# **A1 in Northumberland: Morpeth to Ellingham**

**Scheme Number: TR010059**

## **Applicant's Response to Relevant Representations**

<b>Regulation Reference:</b>	APFP Regulation Rule 8(1)(c)
<b>Planning Inspectorate Scheme Reference</b>	TR010059
<b>Application Document Reference</b>	TR010059/6.7
<b>Author:</b>	A1 in Northumberland: Morpeth to Ellingham Project Team, Highways England

RP Type

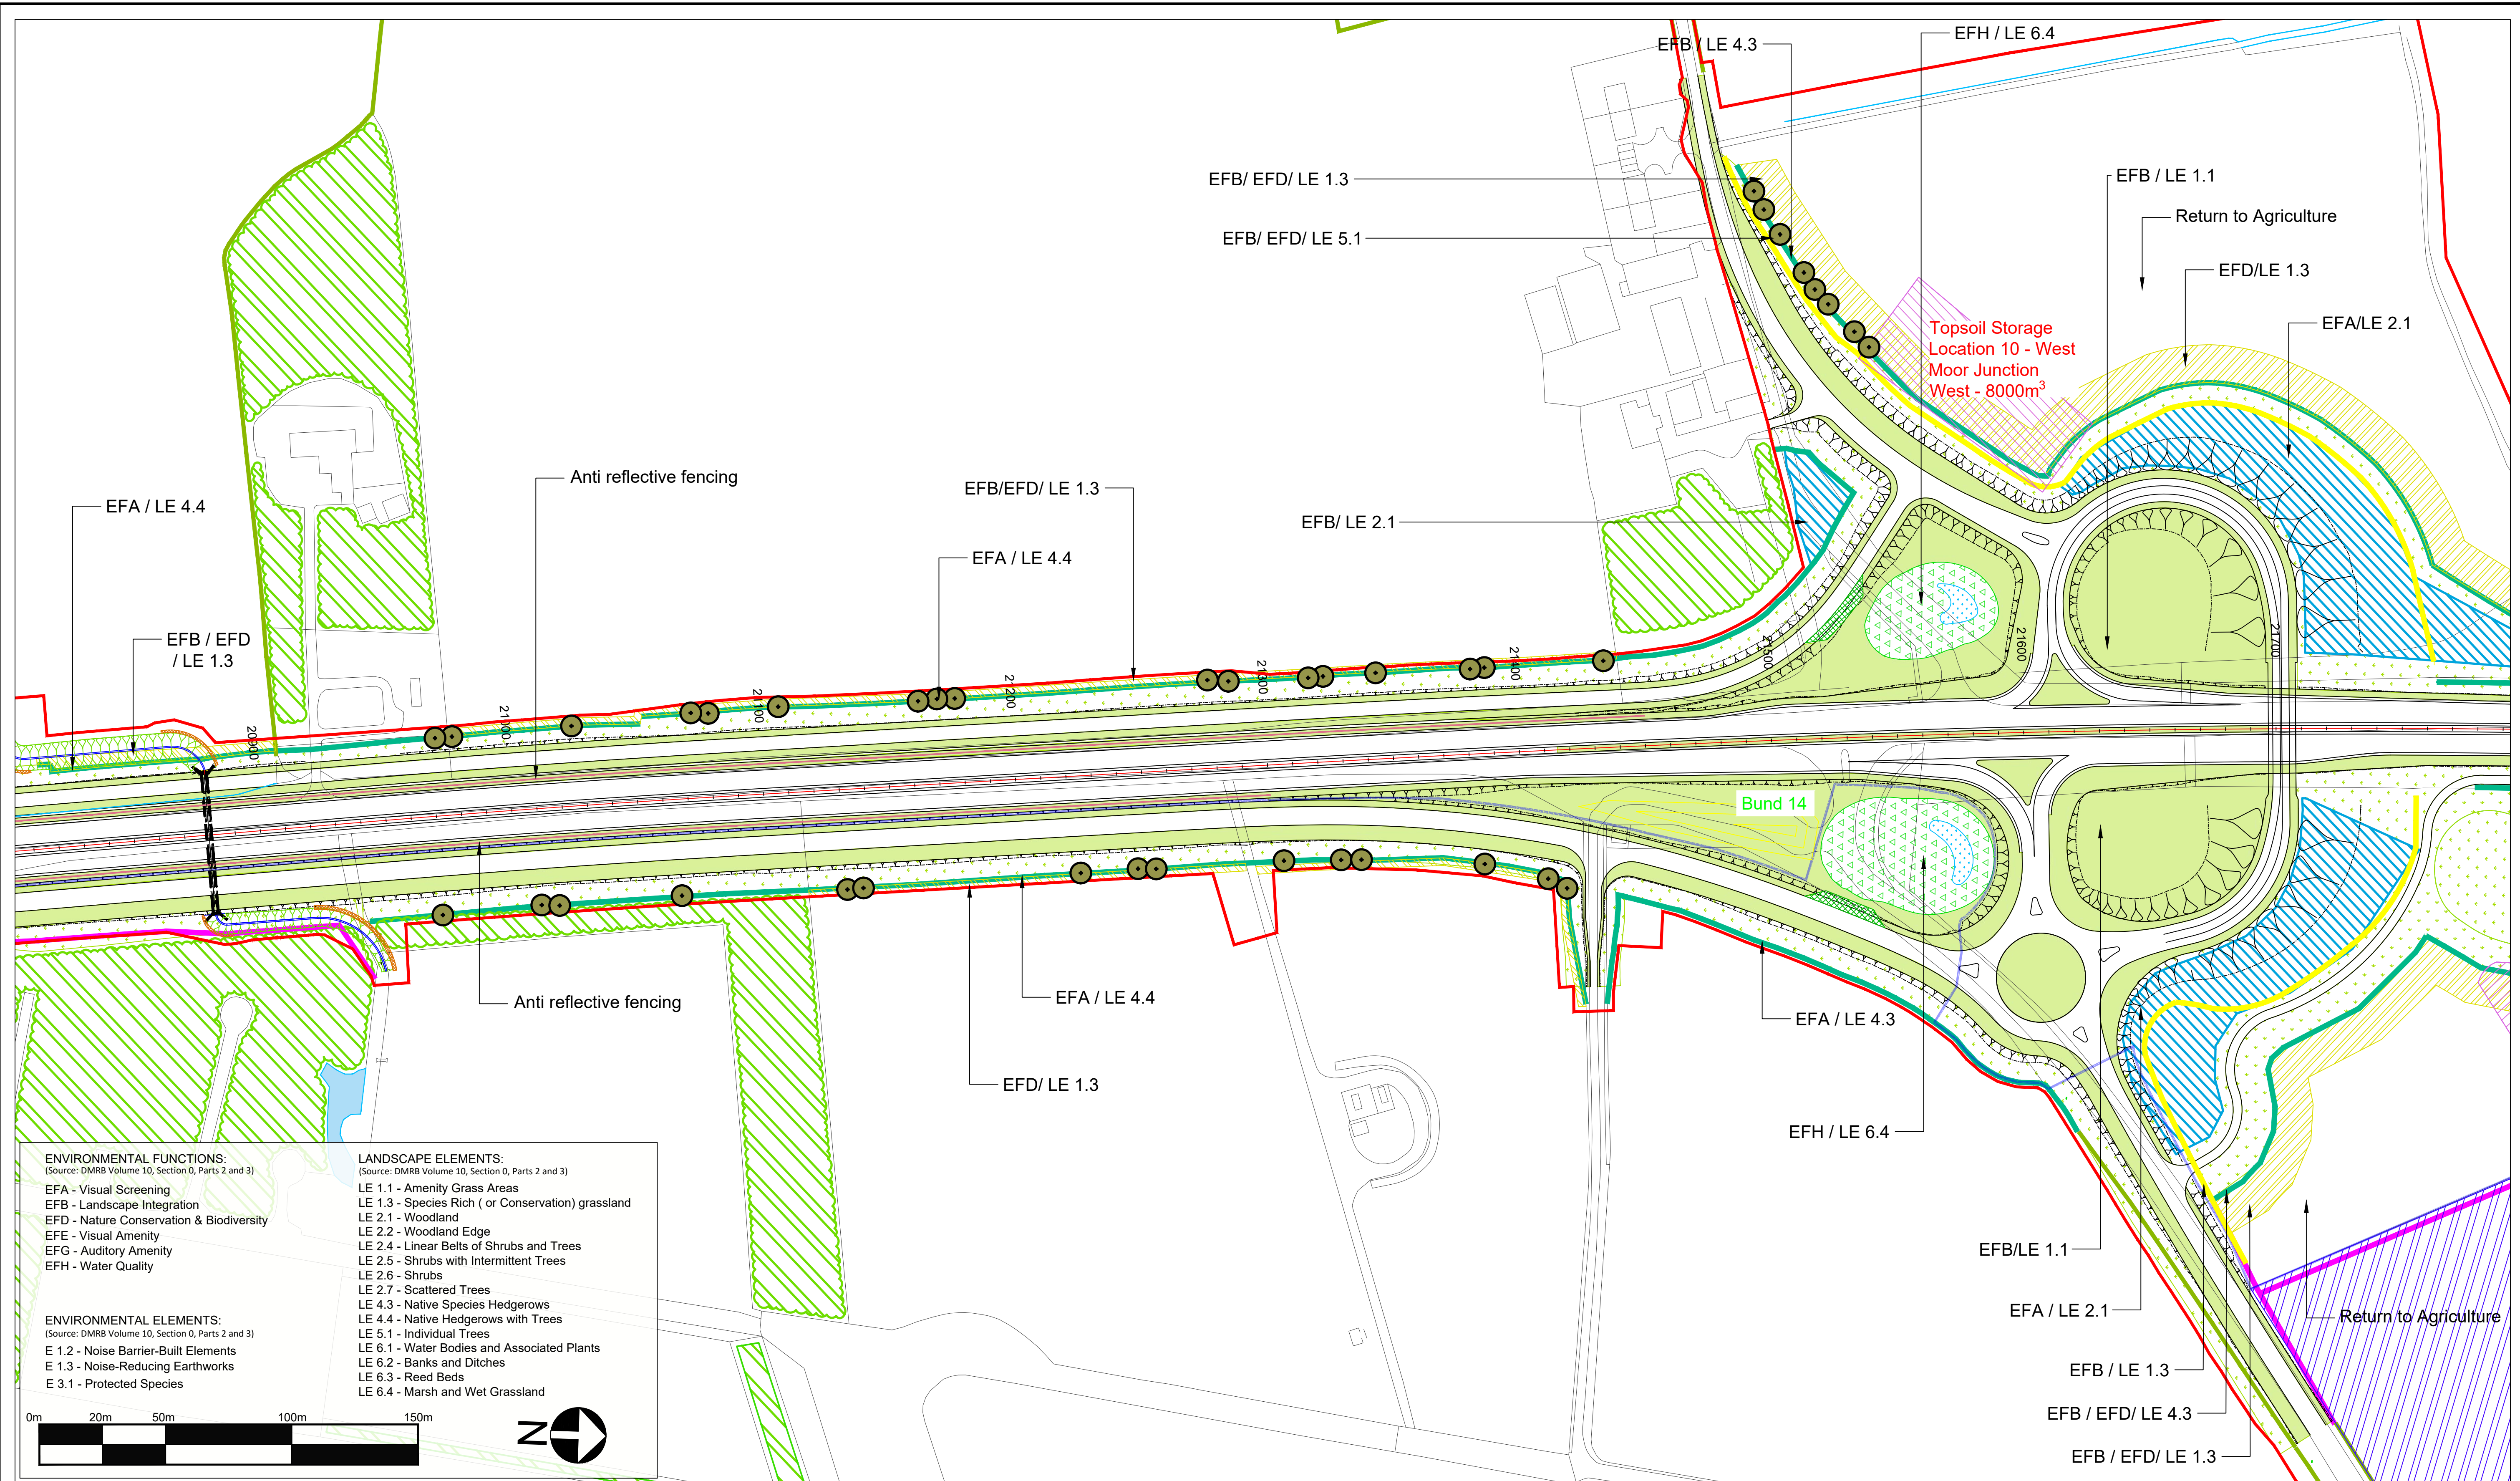
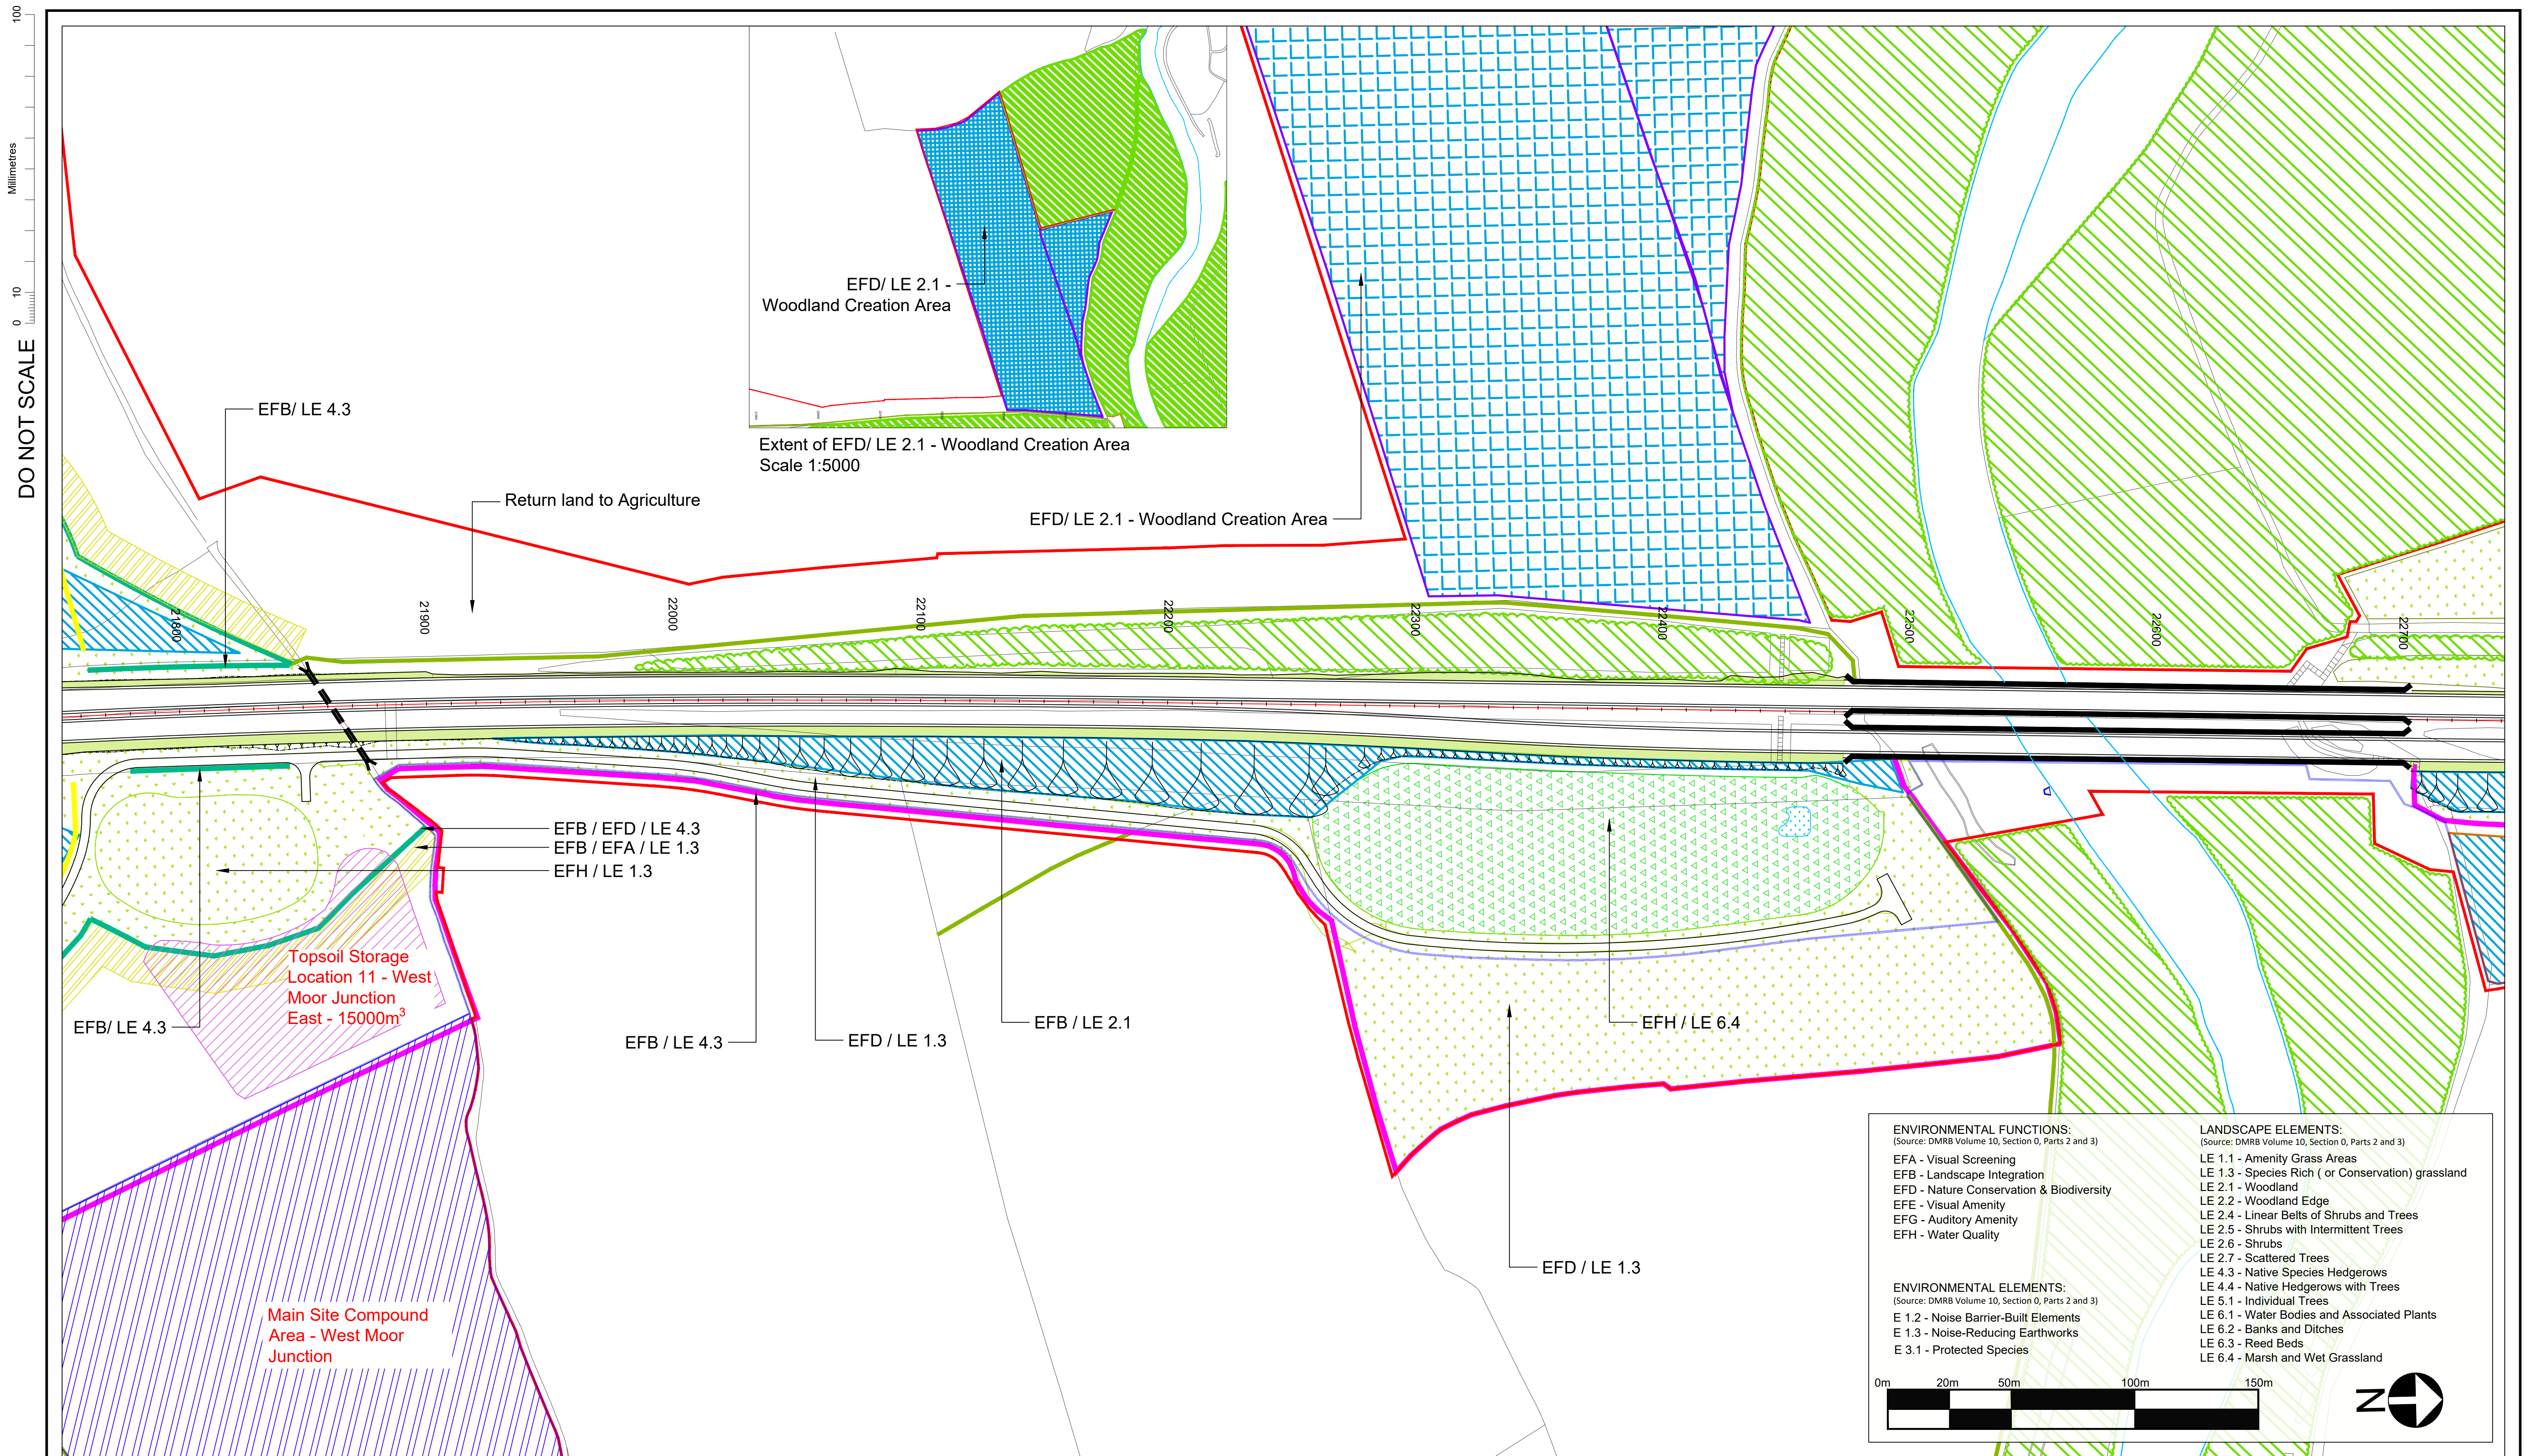
1.1.25	Mitigation for visual effects at Causey Park Bridge appear to be inadequate given the proposals include no vegetative screening for a 4.2m high embankment with a noise fence on top openly seen at a distance of 100-150m from the street and homes. The red line boundary includes an area where planting could have been included to provide some screening.	<ol style="list-style-type: none"> <li>1. The planting strategy associated with Causey Park Bridge does include an element of vegetative screening in the form of a hedge and groups of hedgerow trees that would replicate the existing vegetation to the west of Causey Park Bridge, reflecting the existing characteristics and interrupting views towards the Scheme. In establishing the landscape proposals as set out on Figure 7.8: Landscape Mitigation Masterplan Part A, [APP-095] the Applicant considered that provision of more extensive blocks of planting (trees and shrubs) or long linear belts of woodland, as suggested by NCC, would not be appropriate, as this would substantially change the characteristics and setting to the settlement. These are typically absent within the immediate area, and substantially increasing tree cover would change the open nature of the landscape to the west of Causey Park Bridge. The embankment and specifically the proposed noise barrier would be within the line of sight from receptors within Causey Park Bridge and are anticipated to screen traffic movements. However, despite this, it is anticipated that the effects on the receptors with west facing elevations would be significant during construction and in winter Yr 1, and would remain significant in the summer Yr 15.</li> <li>2. The negative visual effects arising on receptors forming the Causey Park Bridge community could be mitigated further through the adoption of further planting. However, taking the negative effects on landscape character that would arise as a result of the combination of the Scheme and the changes to the open characteristics of the landscape as a result of more extensive blocks of planting (trees and shrubs) or long linear belts of woodland, the proposed mitigation strategy, outlined in Figure 7.8:</li> </ol>

1.1.30	There is an ecological bias to the landscape design, both in narrative and in the resultant design. No information has been provided regarding species selection or management or	<ol style="list-style-type: none"> <li>1. The landscape design is not biased towards ecological mitigation but has sought to reflect the relationship between the different aspects of the assessment. The Applicant has developed the landscape and visual mitigation proposals, set out in Figure 7.8 Landscape Mitigation Masterplan Part</li> </ol>

Reference	Comment from Relevant Representation	Applicant's Response
		Landscape Mitigation Masterplan Part A, [APP-095] is the most appropriate option in terms of landscape character.

Reference	Comment from Relevant Representation	Applicant's Response
	consideration of this in terms of mitigation of landscape and visual effects.	<p>A [APP-095] and Figure 7.10 Landscape Mitigation Plan Part B [APP-144], to address where appropriate, the landscape and visual effects identified during the assessment. These proposals have been developed alongside the project ecologists, as there is a relationship between the landscape, visual and ecological effects arising as a result of the Scheme, and the provision of mitigation measures provided for landscape character or visual effects mitigation must also serve to provide sufficient replacement habitat.</p> <ol style="list-style-type: none"> <li>2. The Applicant has, within Section 7.9 Design, Mitigation and Enhancement Measures, of both Chapter 7: Landscape and Visual, Part A [APP-044] and Chapter 7: Landscape and Visual, Part B [APP-045], stated how embedded mitigation and specific mitigation measures to address landscape and visual effects should be incorporated into the detailed design.</li> <li>3. Issues of species selection would be addressed at the detailed design stage based on this requirement but would reflect the species found locally and would comprise native species, this is identified in:</li> <li>4. Part A: <ul style="list-style-type: none"> <li>• Paragraph 7.9.14, item c, native tree and shrub species would be in keeping with local landscape character</li> </ul> </li> <li>5. Part B: <ul style="list-style-type: none"> <li>• Paragraph 7.9.4, item c, the incorporation of species rich hedgerows</li> <li>• Paragraph 7.9.13, items b and f, the incorporation of native species in keeping with the local landscape character.</li> </ul> </li> <li>6. Depending upon the species selected and the final design of the measures to deliver mitigation, the management of the mitigation features would be included within a landscape scheme to be approved by the SoS following consultation with NCC, as part of Schedule 2, Requirement 5 of the draft DCO. These measures are secured within the items S-L1 – S-L5, S-L9 of Table 3-1 - Register of Environmental Actions and Commitments: The Scheme, in the Outline CEMP [APP-346]. Mitigation measures would be monitored during the establishment period to ensure their delivery through items S-L11 – S-L13 of the same document.</li> <li>7. In addition, the Outline CEMP [APP-346], prepared and updated through the design and delivery phases would be subsequently converted to a Handover Environmental Management Plan (HEMP) to secure the long-term establishment of the mitigation measures required by the Scheme. Mitigation measures would be monitored during the establishment period to ensure their delivery through items S-L11 – S-L13 of the same document.</li> </ol>
